National Highways Planning Response (NHPR 21-09) Formal Recommendation to an Application for Planning Permission

Council's Reference: 21/03267/OUT

Location: OS Parcel 0006, Southeast of Baynards House adjoining A43, Baynards Green

National Highways Ref: 92857

BOUNDARY SECTIONS 11-15

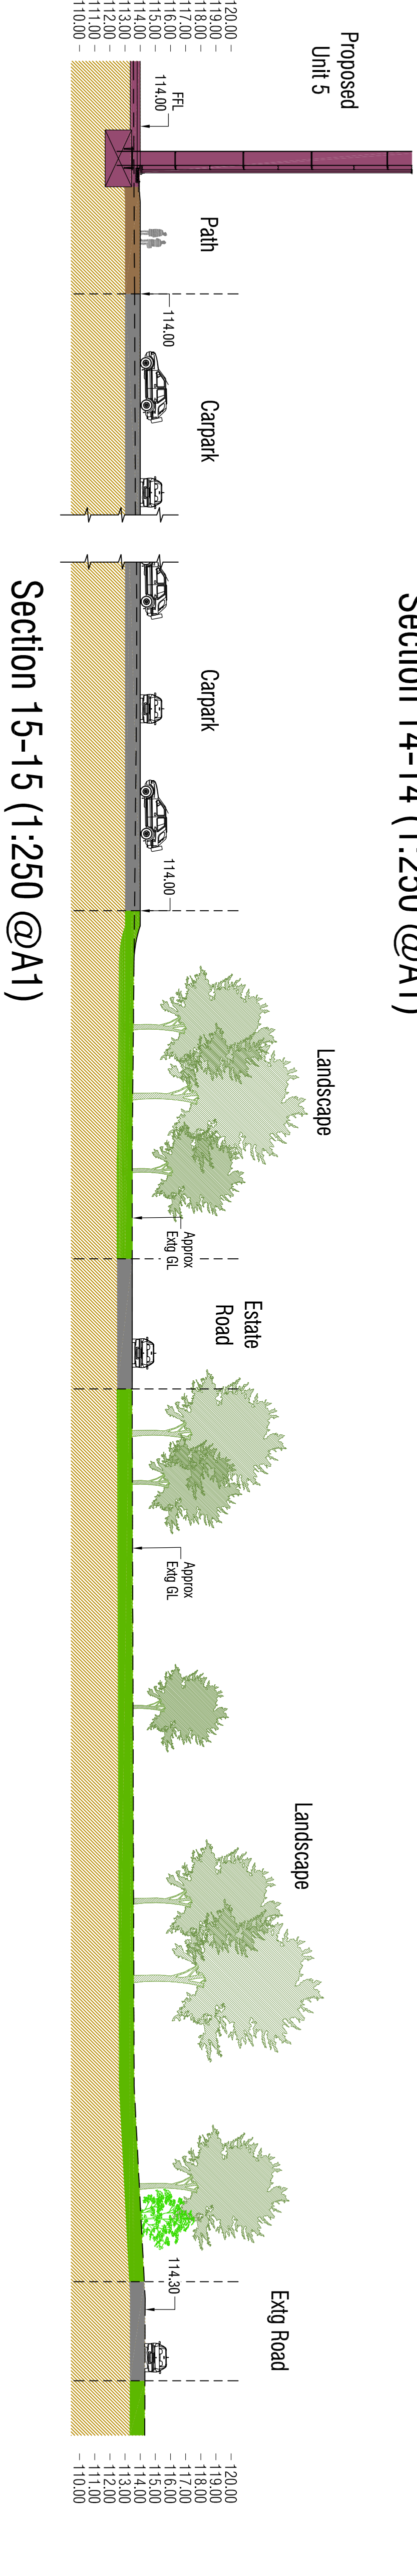
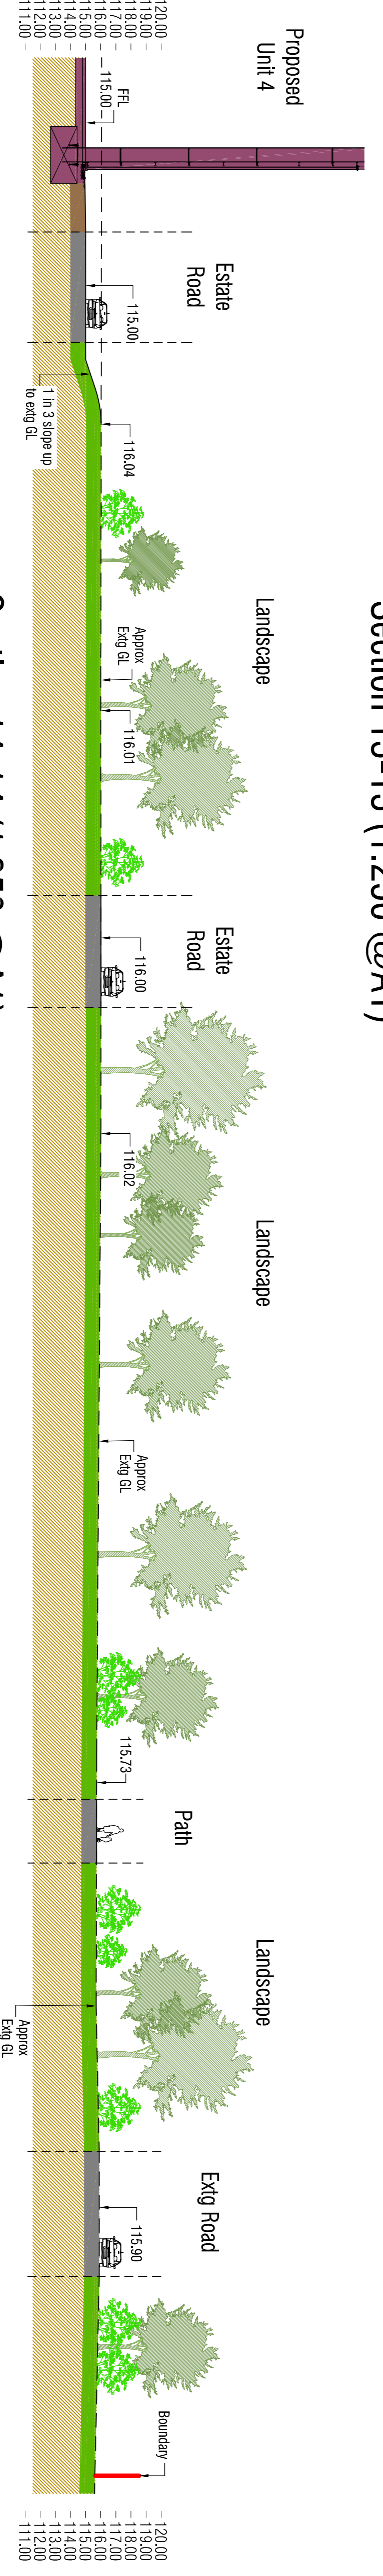
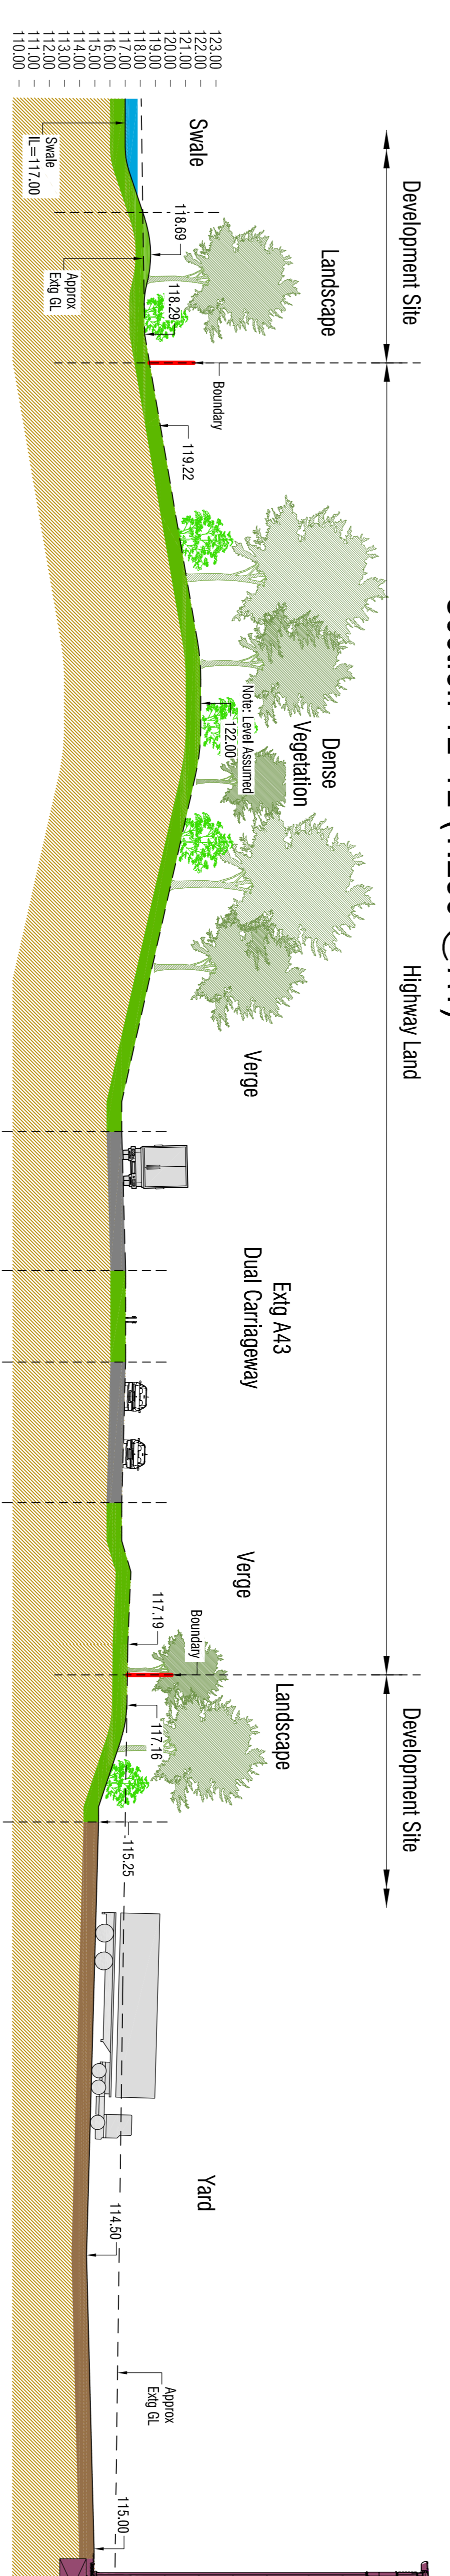
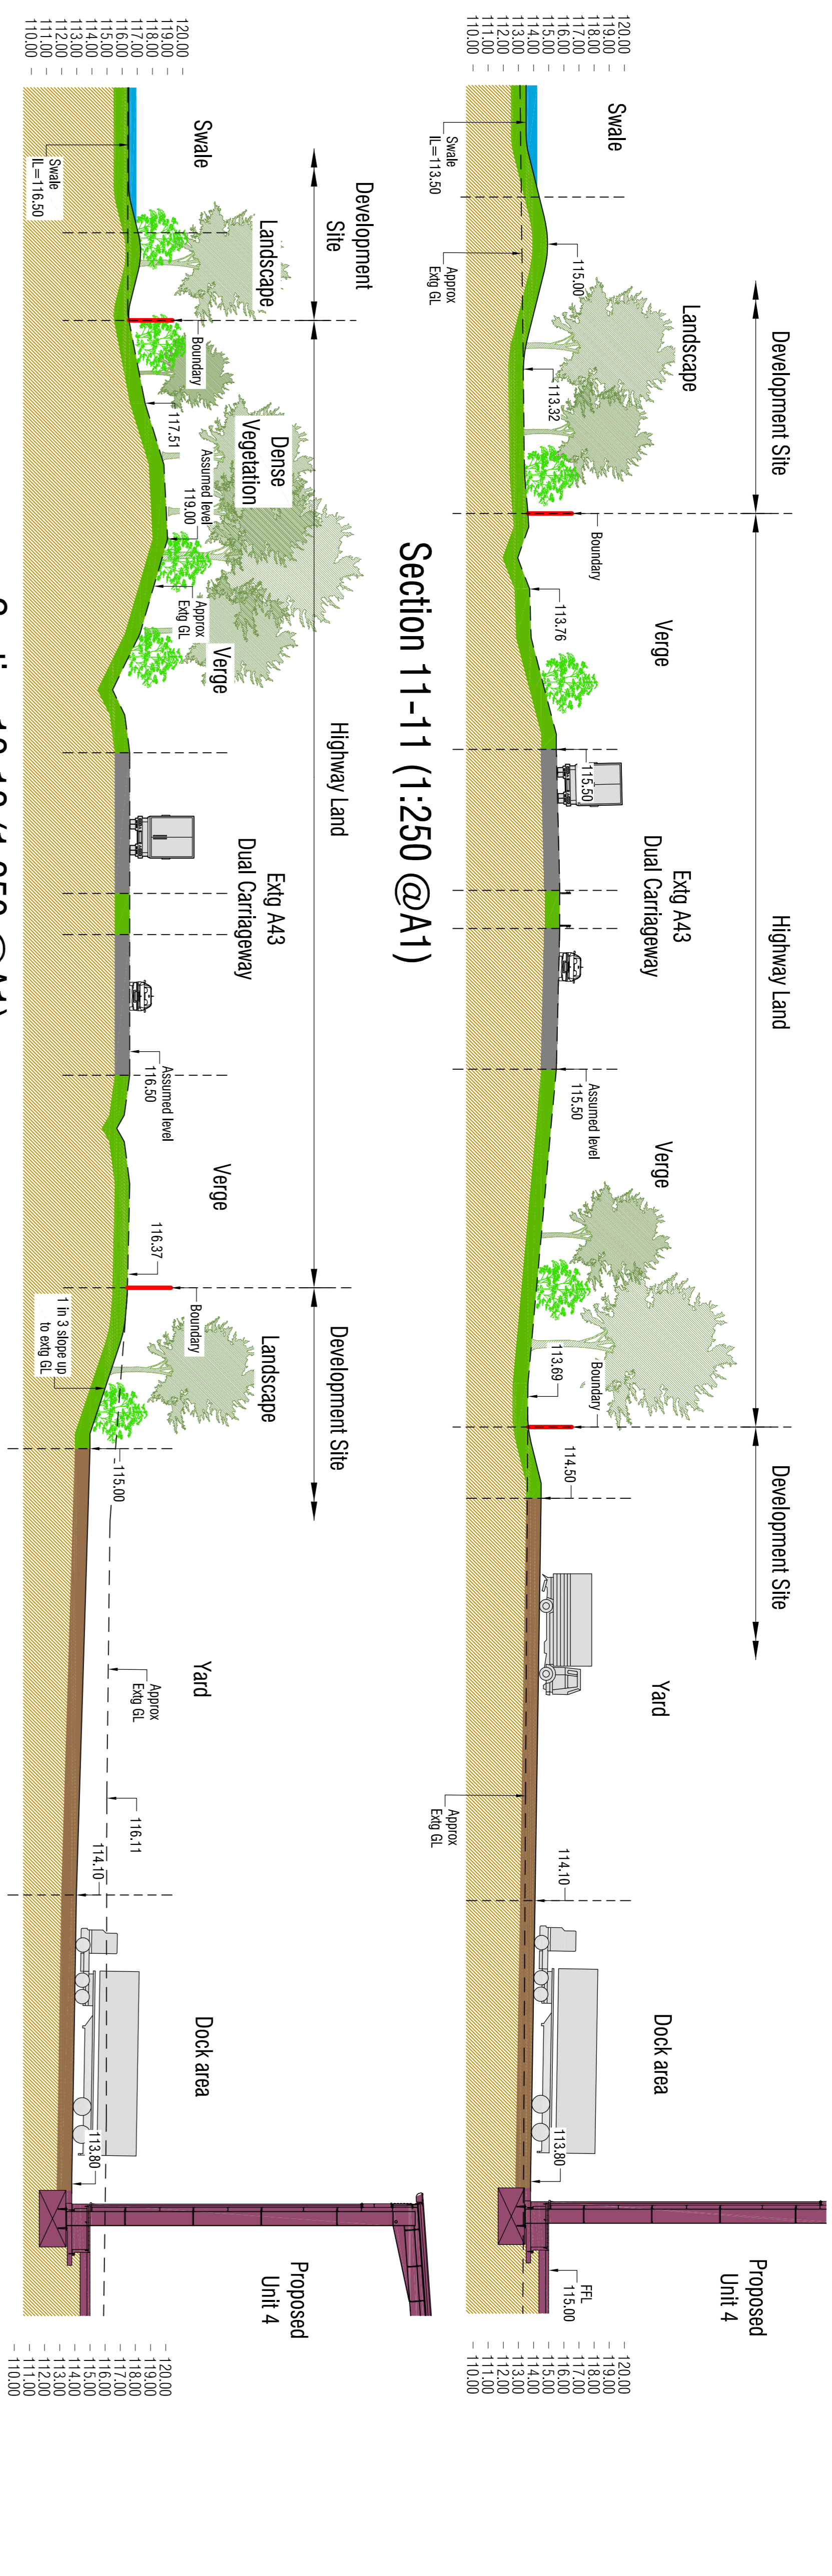
In addition, the submitted preliminary Ground Investigation report is a geo-environmental Phase 2 investigation for the main developments themselves. It does not include any details of the boundaries with National Highways operations, aside from a comment about excavations in (Part 1(2) (1).pdf):

The applicant will need to advise / confirm if there will be any earthworks associated with the development(s) in relatively close proximity to National Highways boundaries (e.g. the stability of the balancing ponds, etc). In the first instance, some cross sections (to scale) through the boundaries showing the proposed extent of the development, its features and any proposed changes in elevation (excavations, landscaping) etc should be submitted for further assessment. Once received, we will review to determine the possible extent of any geotechnical reporting under the Design Manual for Roads and Bridges (DMRB) standard CD 622, which may be required to confirm the extent of any geotechnical risk to the SRN.

JOB TITLE		M40 JUNCTION 10		CLIENT		ALBION LAND	
DRAWING TITLE							
EASTERN ACCESS GENERAL ARRANGEMENT PRE-GROWTH FUND SCHEME							
SCALE	DRAWN BY	DATE	DRAWING No	REVISION			
1:500@A1	RM	03/08/21	17213-16-GA	P0

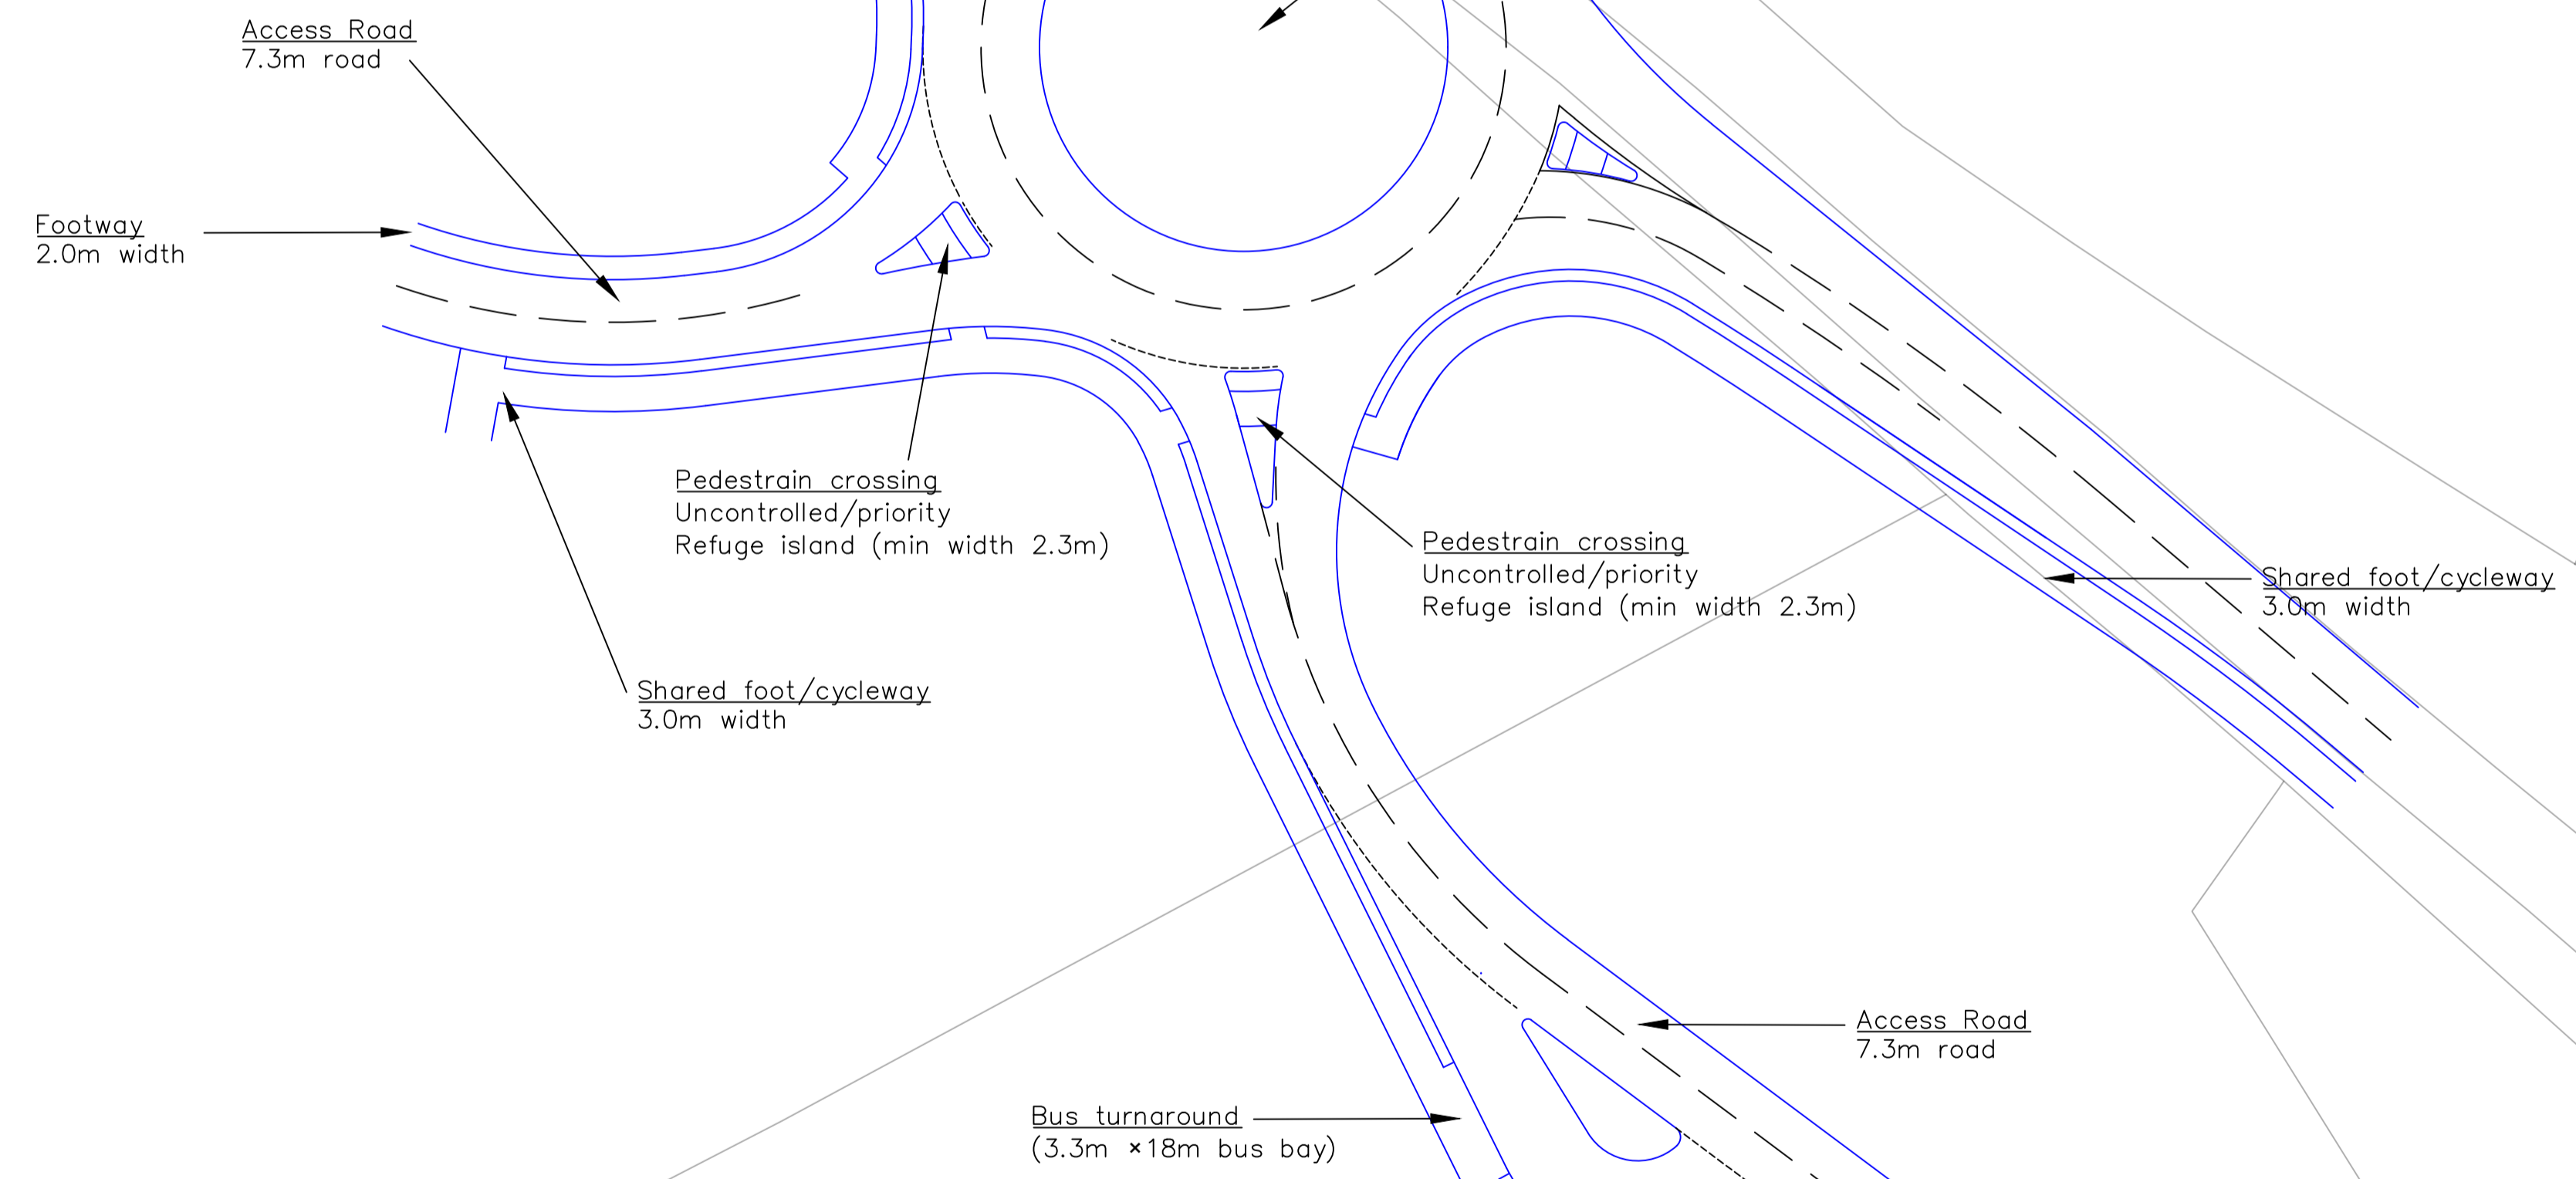
The applicant has proposed an interim mitigation scheme at the A43 Baynards Green roundabout which includes widening of the B4100 entries and a standalone signal-controlled toucan (pedestrian and cycle) crossing.

Given the concerns set out above and the uncertainty of some elements of the Growth Deal, there remain outstanding concerns. National Highways is therefore not yet in a position to comment on the suitability of the interim mitigation scheme.
